PLANNING CONSULTATION RESPONSE

Application No	2026/0640
Proposal	Residential development of 270 new dwellings, together with access, public open space, landscaping, drainage infrastructure and associated works
Address	Land south of Cemetery Road, Jump, Barnsley, S73 0QN
Date of Consultation Reply	29/09/2026
Consultee	Claire Wilson, Planning Ecologist

Figure 1: Baseline Habitat Plan

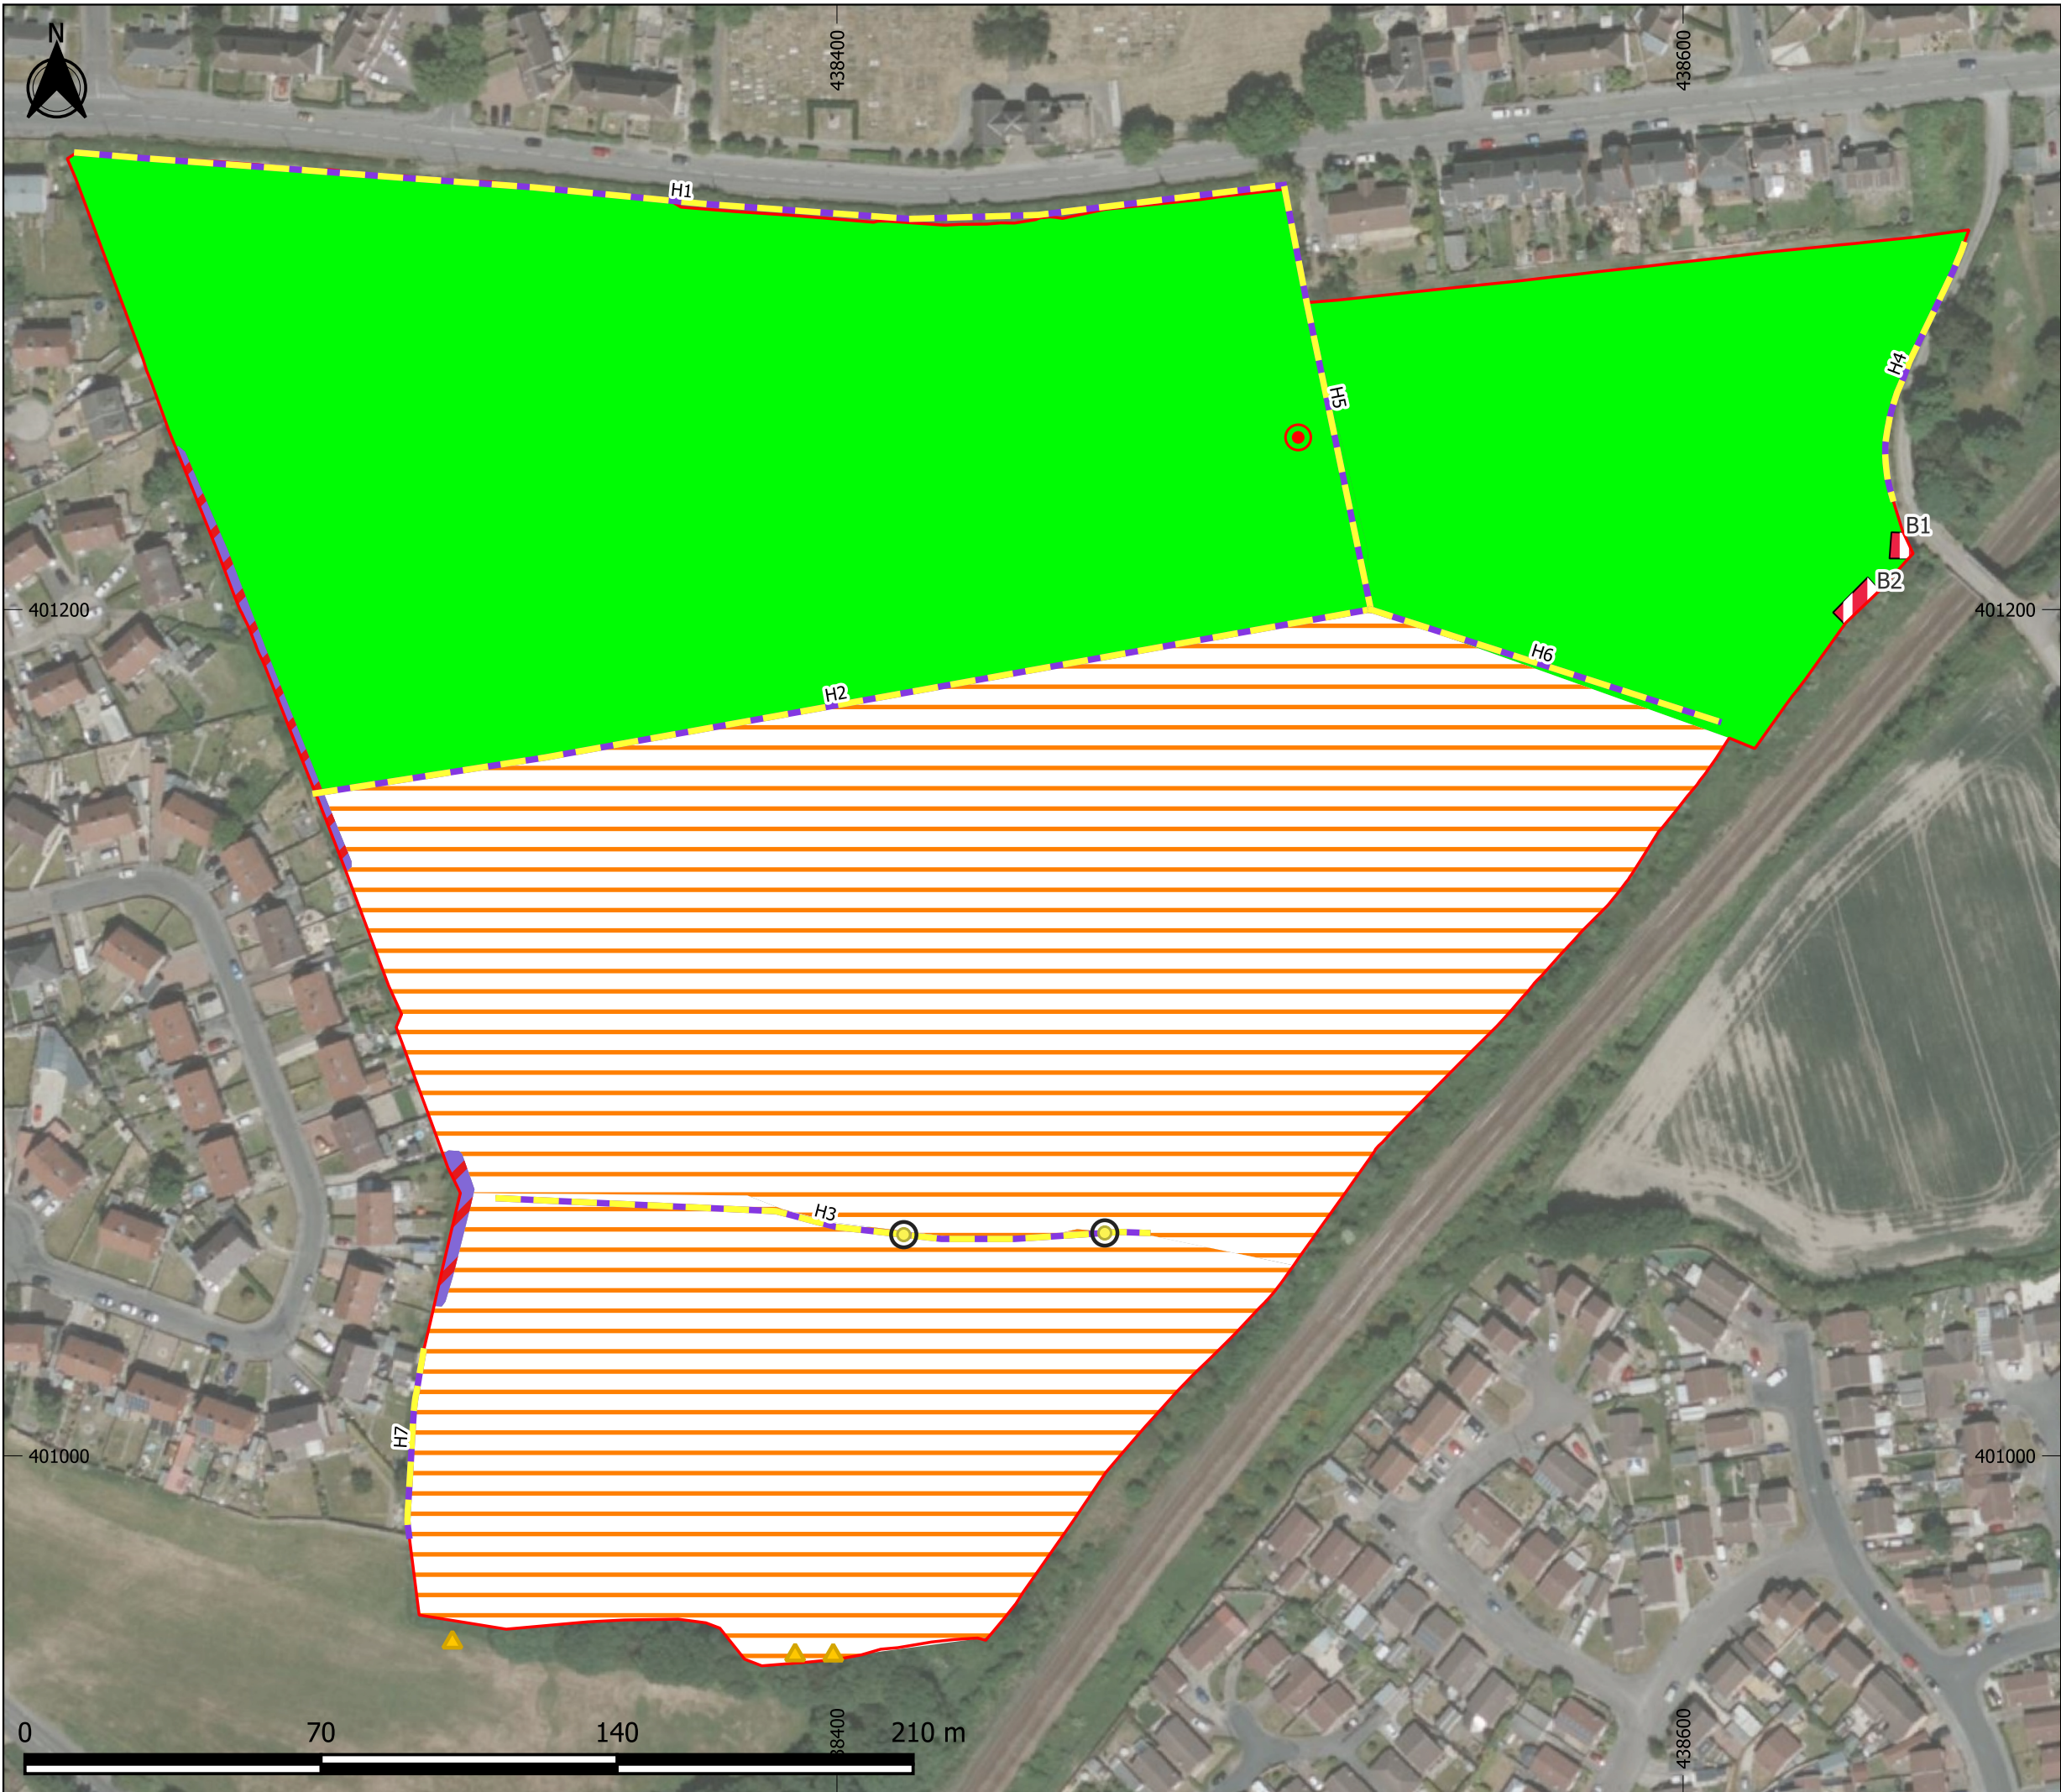
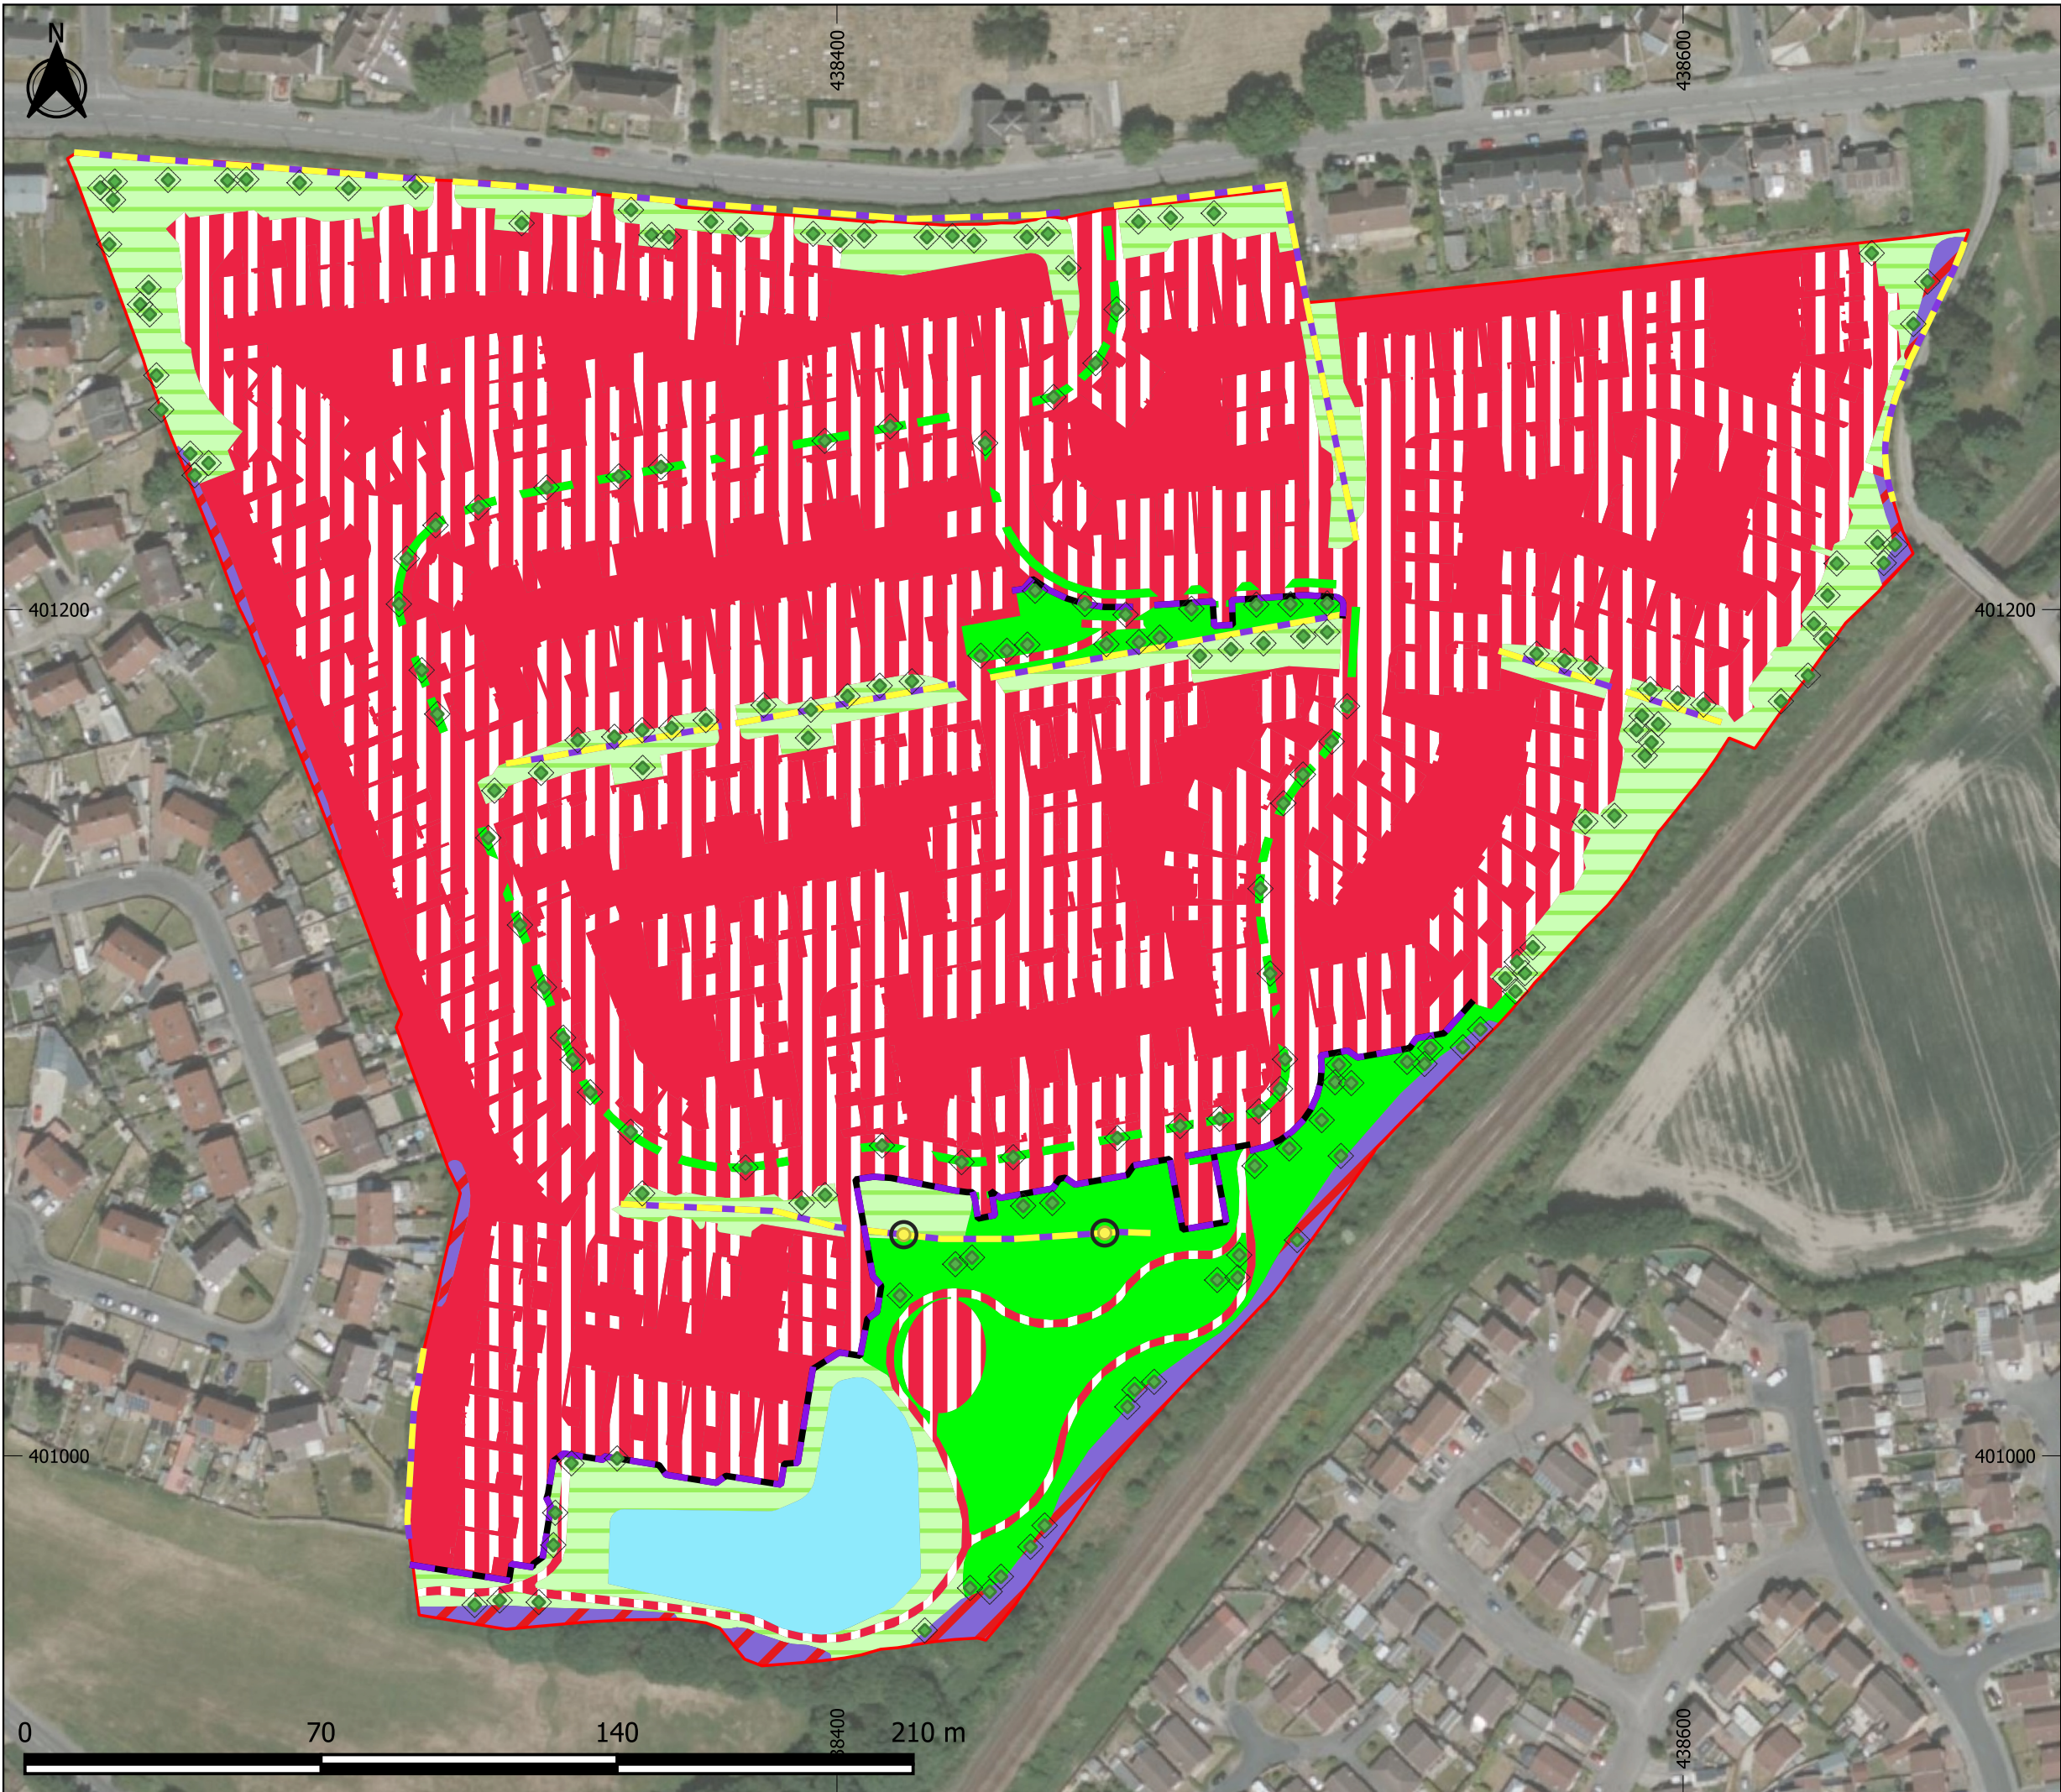
- The Biodiversity Net Gain (BNG) assessment indicates that the majority of retained hedgerows will remain in good condition. However, a review of the proposed layout suggests that many retained hedgerows will be located directly adjacent to residential development and modified grassland and will be fragmented by roads, dwellings and areas of public open space. Under these circumstances, it is unlikely that the hedgerows will be capable of maintaining their current condition. The submitted metric should therefore be reviewed in accordance with statutory metric guidance on habitat retention, which requires retained habitats to remain in their baseline condition and where this cannot be achieved, habitats should be treated as lost and re-created.

- Mixed scrub, other neutral grassland and species rich native hedgerows within the post development metric are proposed to achieve moderate/good condition. However, following a review of the landscaping scheme I do not consider these conditions realistic or achievable, especially within the centre of the site when the potential for trampling/damage is high. As such, the post development habitats and their condition should be reviewed to ensure their creation is possible.

LANDSCAPE MASTERPLAN

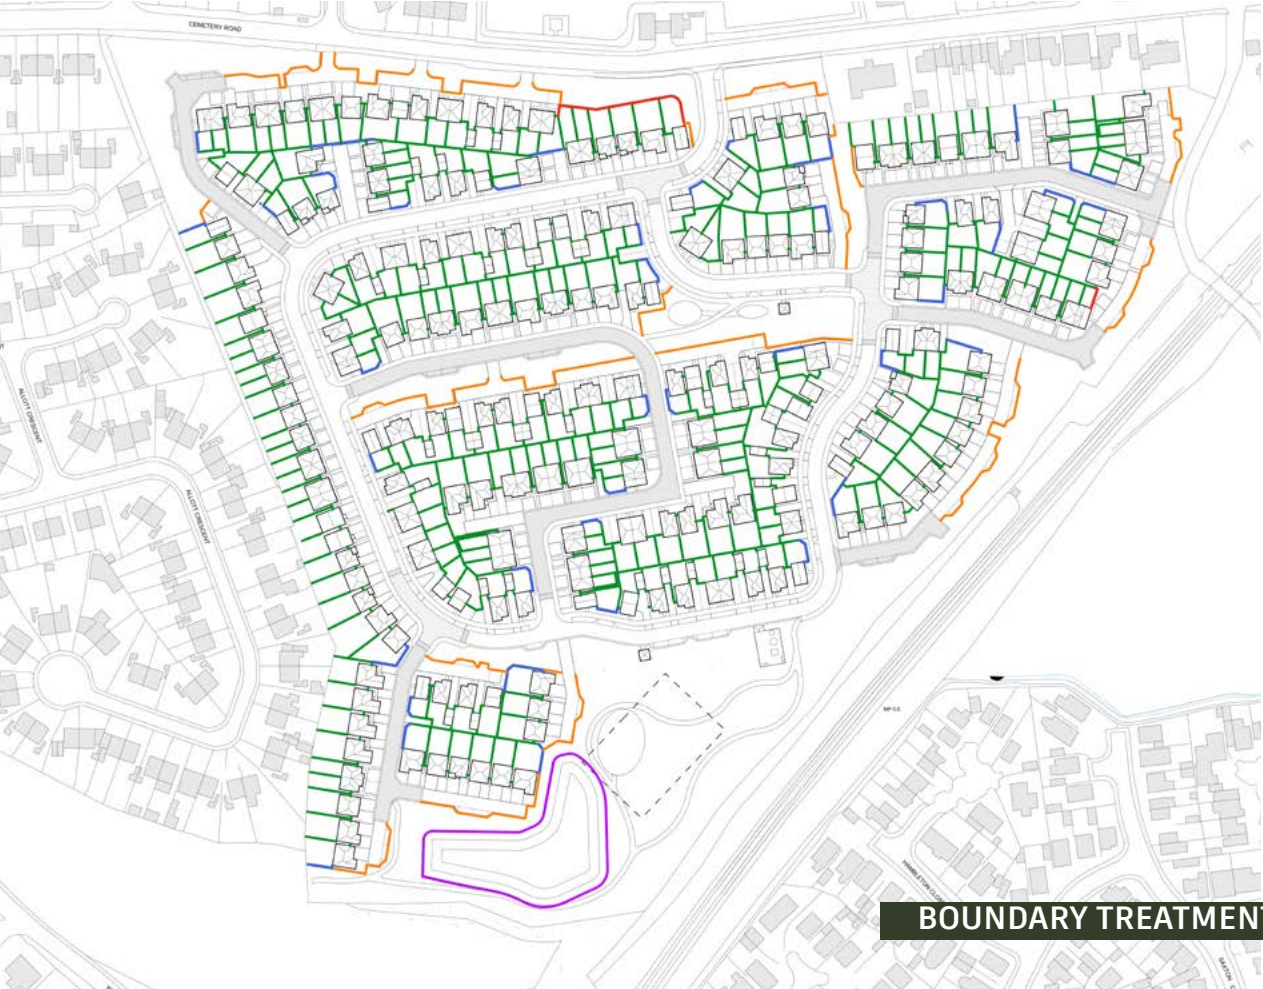
- Following review of the submitted plans, clarification is required regarding the provision of four separate access points through the northern hedgerow. A single access point is considered acceptable where an existing gap is present opposite Preston Avenue, as this would minimise impacts on the hedgerow. However, the need for three additional access points has not been justified and does not adhere to the mitigation hierarchy. The Landscape Masterplan should be revised to minimise impacts to H1 to maximise retention of the feature.

- The proposed ecological buffers along the southern and eastern boundaries do not appear sufficient enough to maintain an effective dark corridor for commuting and foraging bats. The applicant should confirm the proposed buffer widths. These buffers should comprise woodland and scrub planting to maintain habitat connectivity, provide foraging opportunities and reduce the impacts of artificial lighting.
